PLANNING APPLICATION CONSULTATION RESPONSE

Application Number:	3/2020/0911
Location:	Shackleton Garden Centre, Clitheroe Road, Chatburn
Proposal:	Proposed extension and remodelling of home and garden centre, including additional indoor and outdoor retail space and increased café area and play area.

Lead Local Flood Authority (LLFA) Position

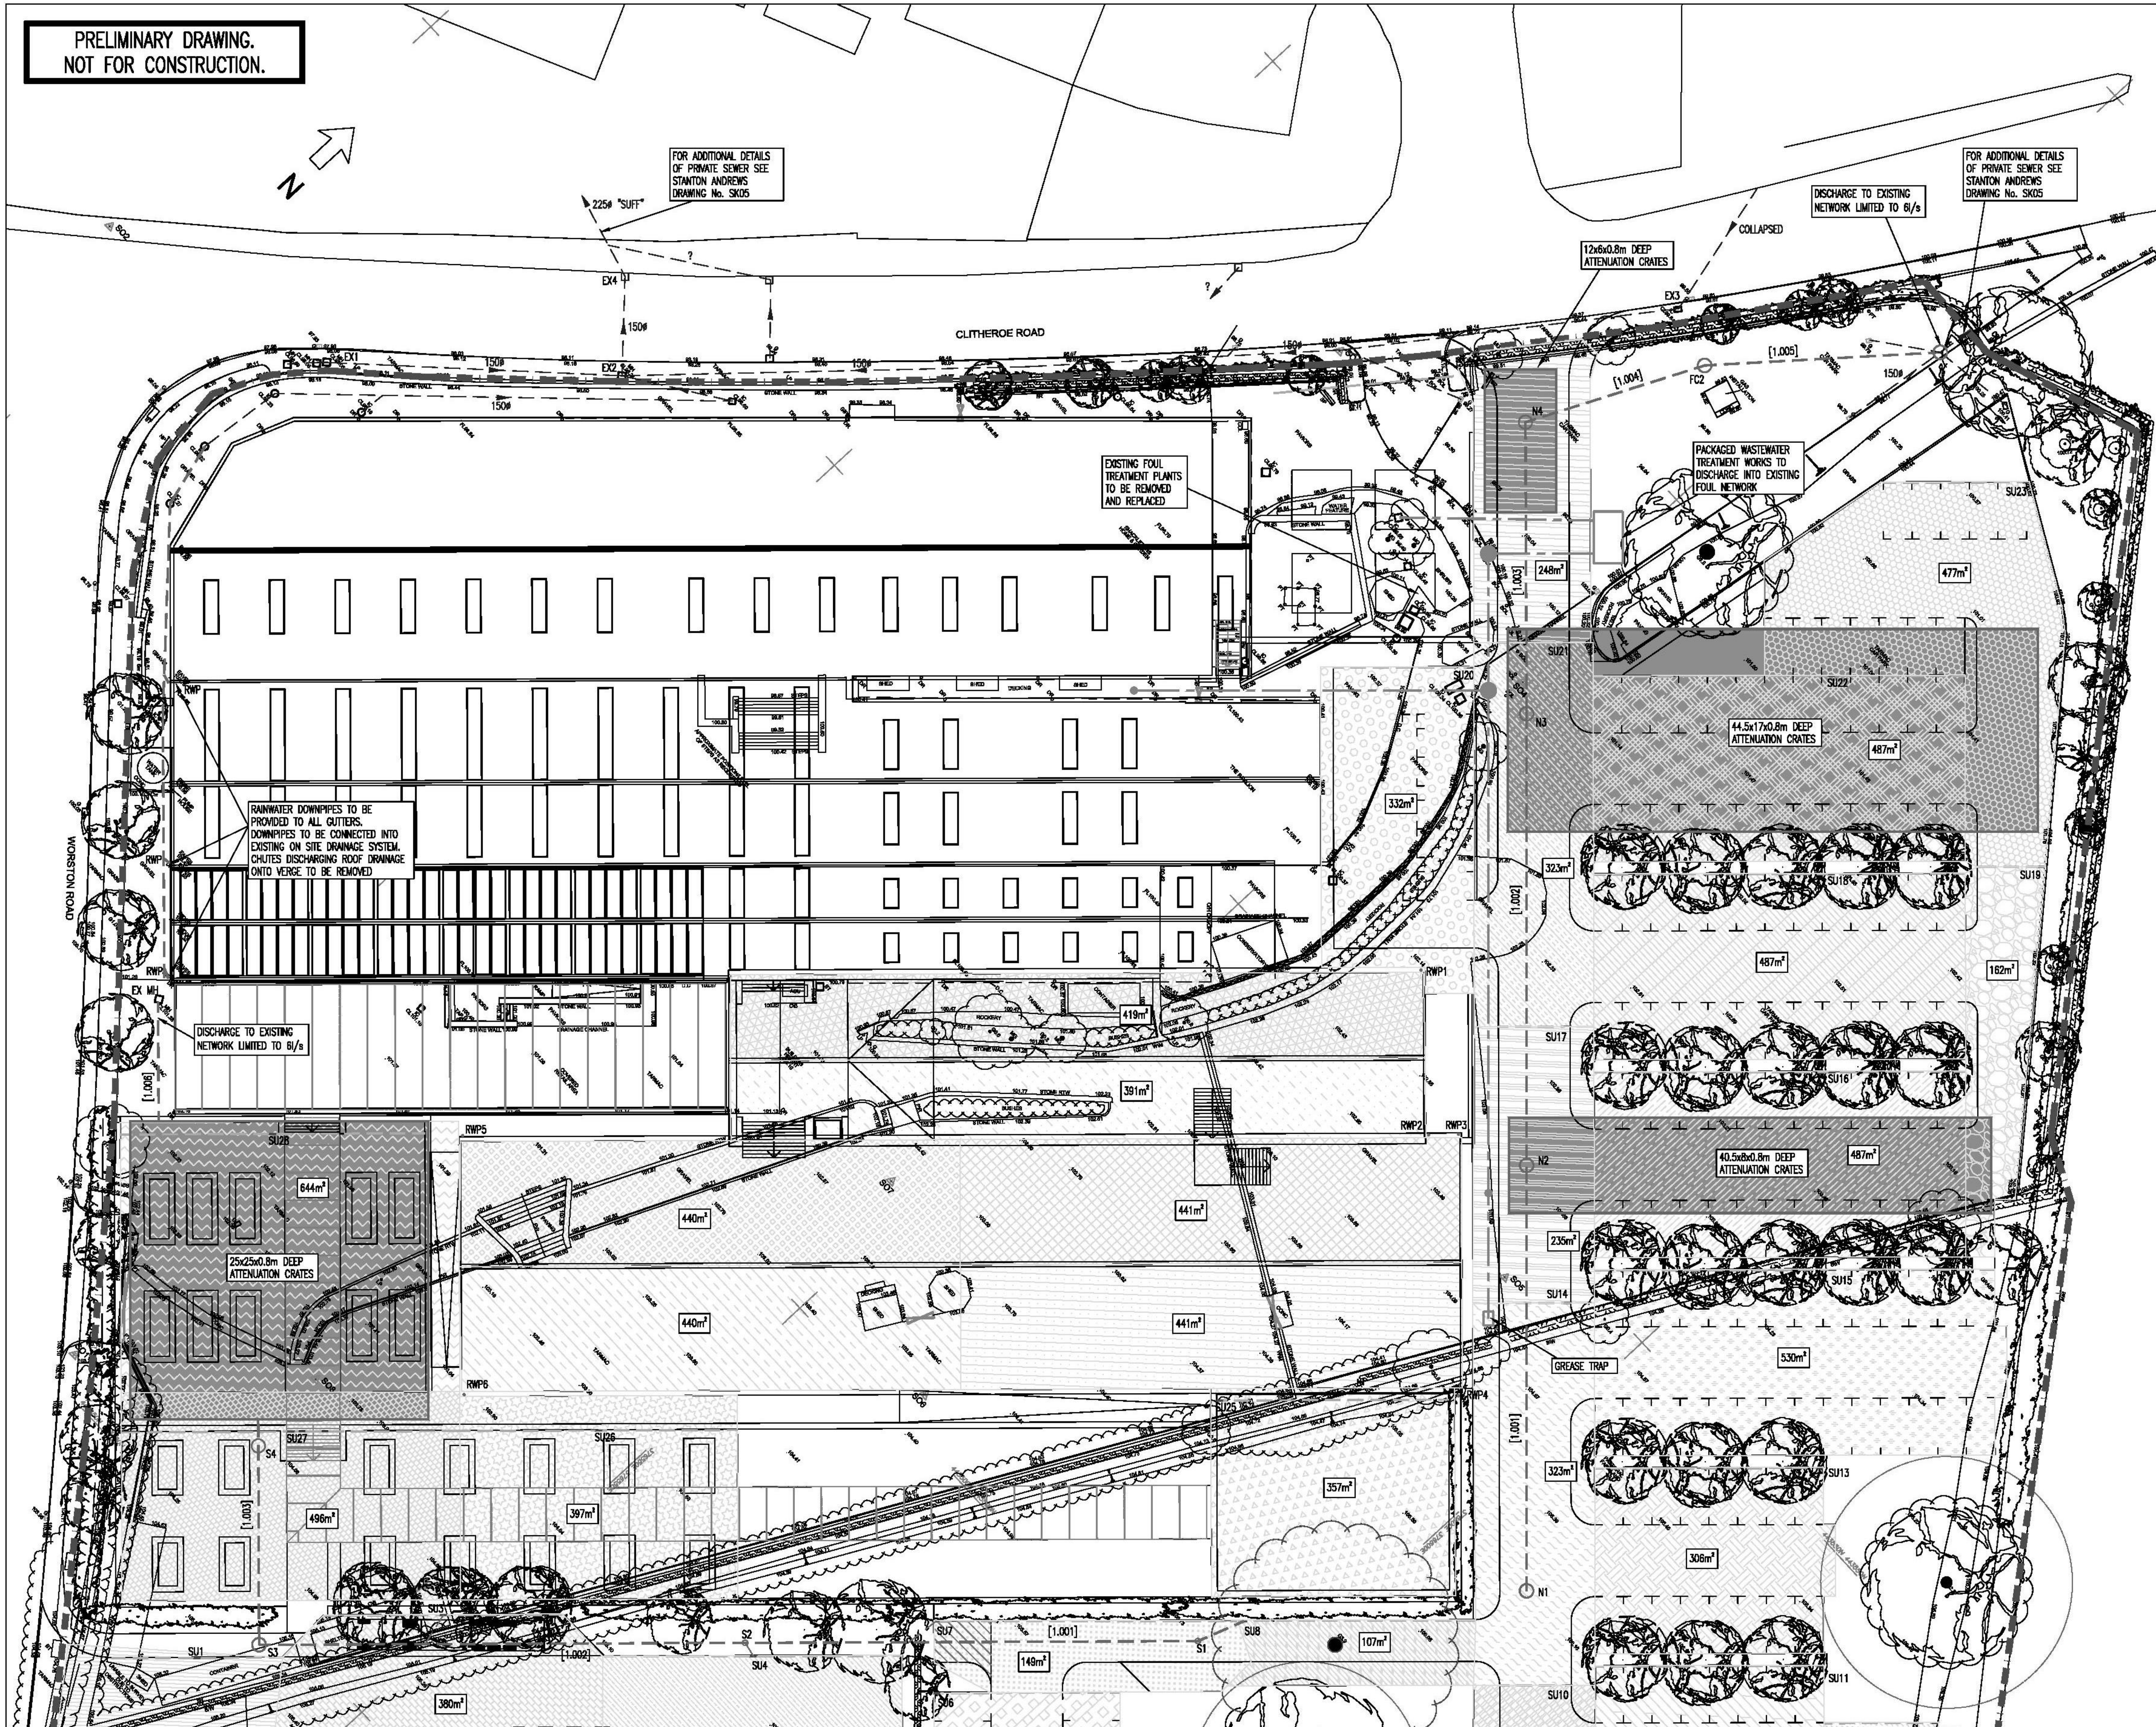
The LLFA notes that the southern part of the site is to drain to a 25x25x0.8m deep attenuation crate, which will then connect to manhole 'EX MH' at the south west corner of the existing building (Project 10301 / Drawing 101 / Issue P3). It is not clear where this manhole then connects to and if it currently drains surface water from the southern part of the site. This will need to be addressed in the final drainage strategy, with evidence that confirms the receiving drain is sufficiently sized and is in sufficient condition to accept additional surface water runoff generated by the development.
